Planning Application No: 3/2025/0783

Proposal: Proposed two storey extension to rear of property to create additional living accommodation.

Location: 2 Cherry Tree Road Whalley BB7 9YH

Whalley Parish Council wish to comment on the above planning application.

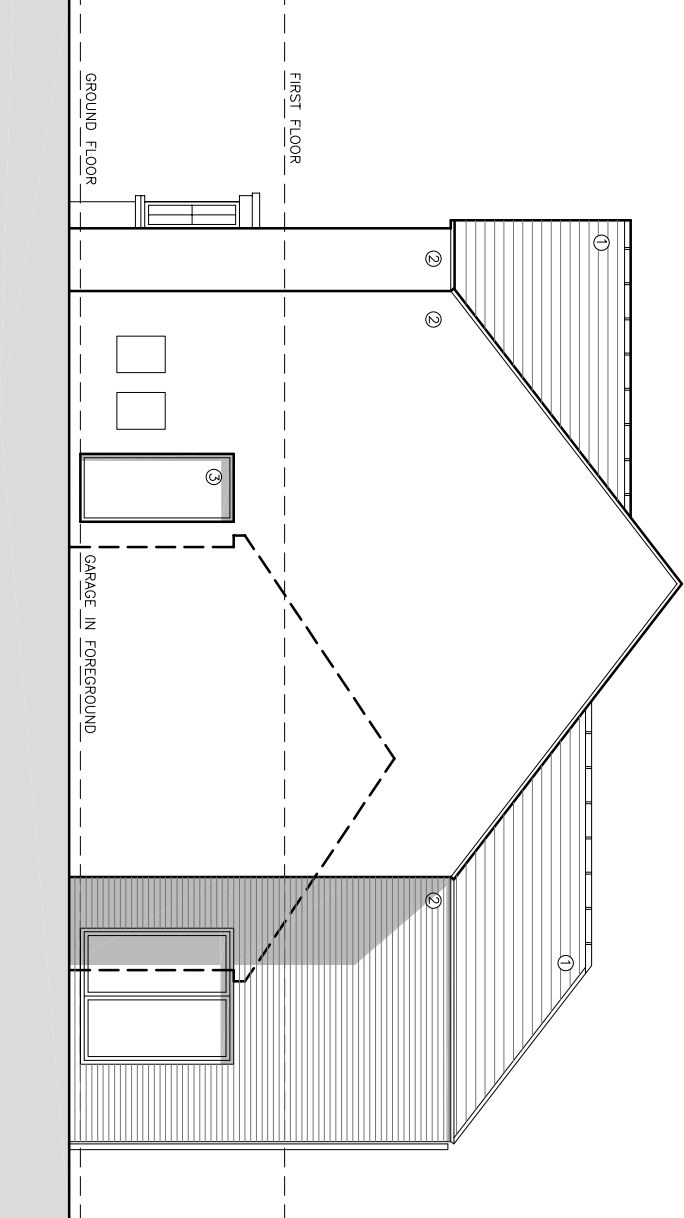
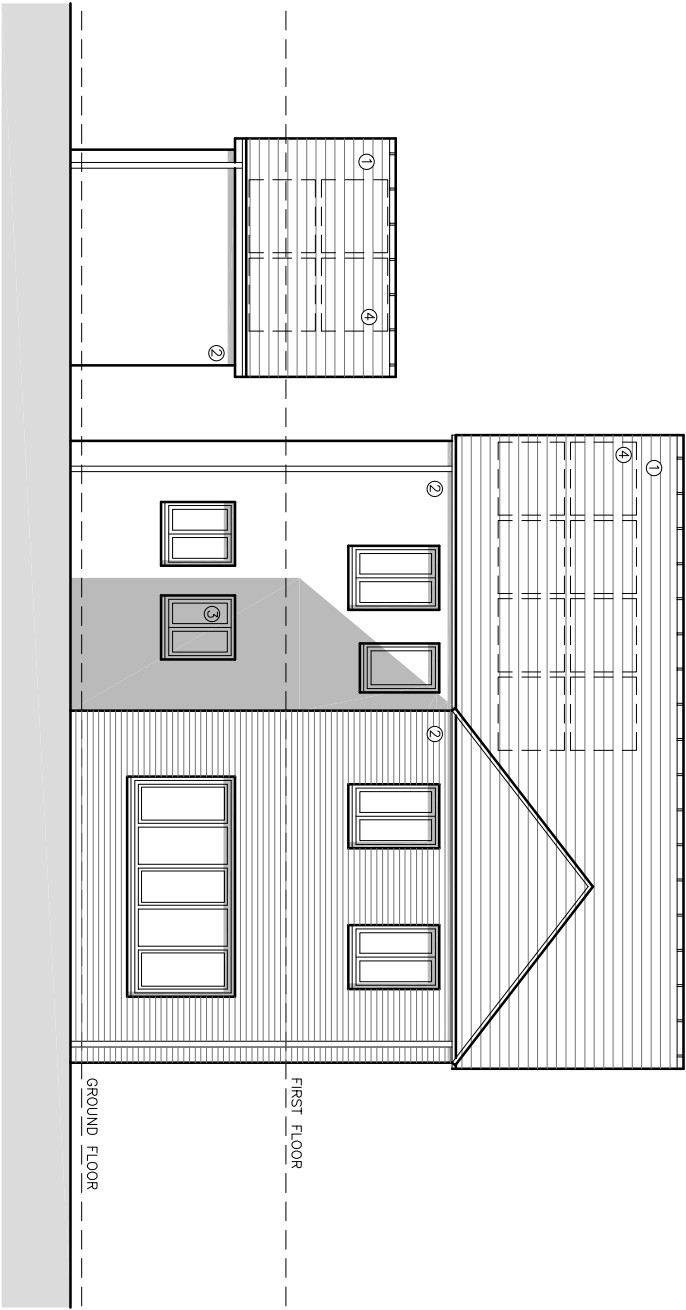
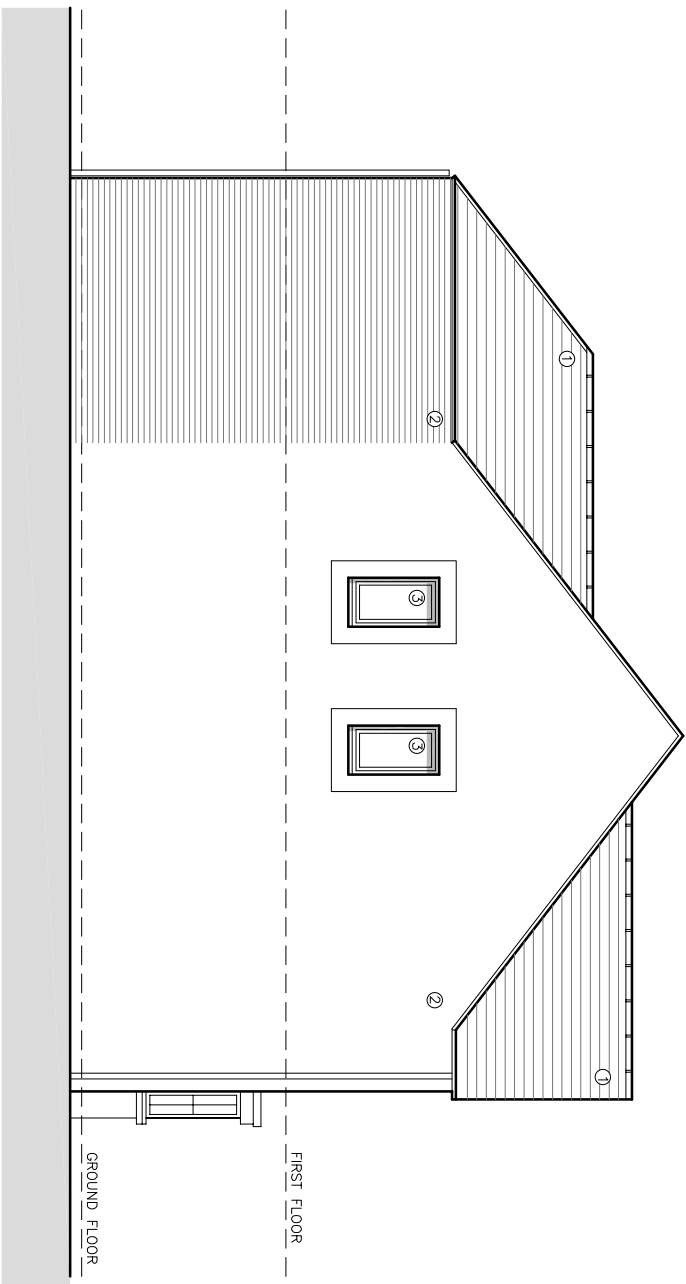
While the Parish Council acknowledges the homeowner's desire to improve and extend their property, we have concerns regarding potential overlooking and loss of privacy arising from the proposed window placement.

Due to the height and rear-facing nature of the extension, any upper-floor windows may have direct views into adjoining properties. This raises issues regarding the privacy of neighbouring residents.

We respectfully request that the Planning Authority considers whether appropriate measures are required to mitigate this impact. This could include the use of obscure glazing, redesign or repositioning of windows.
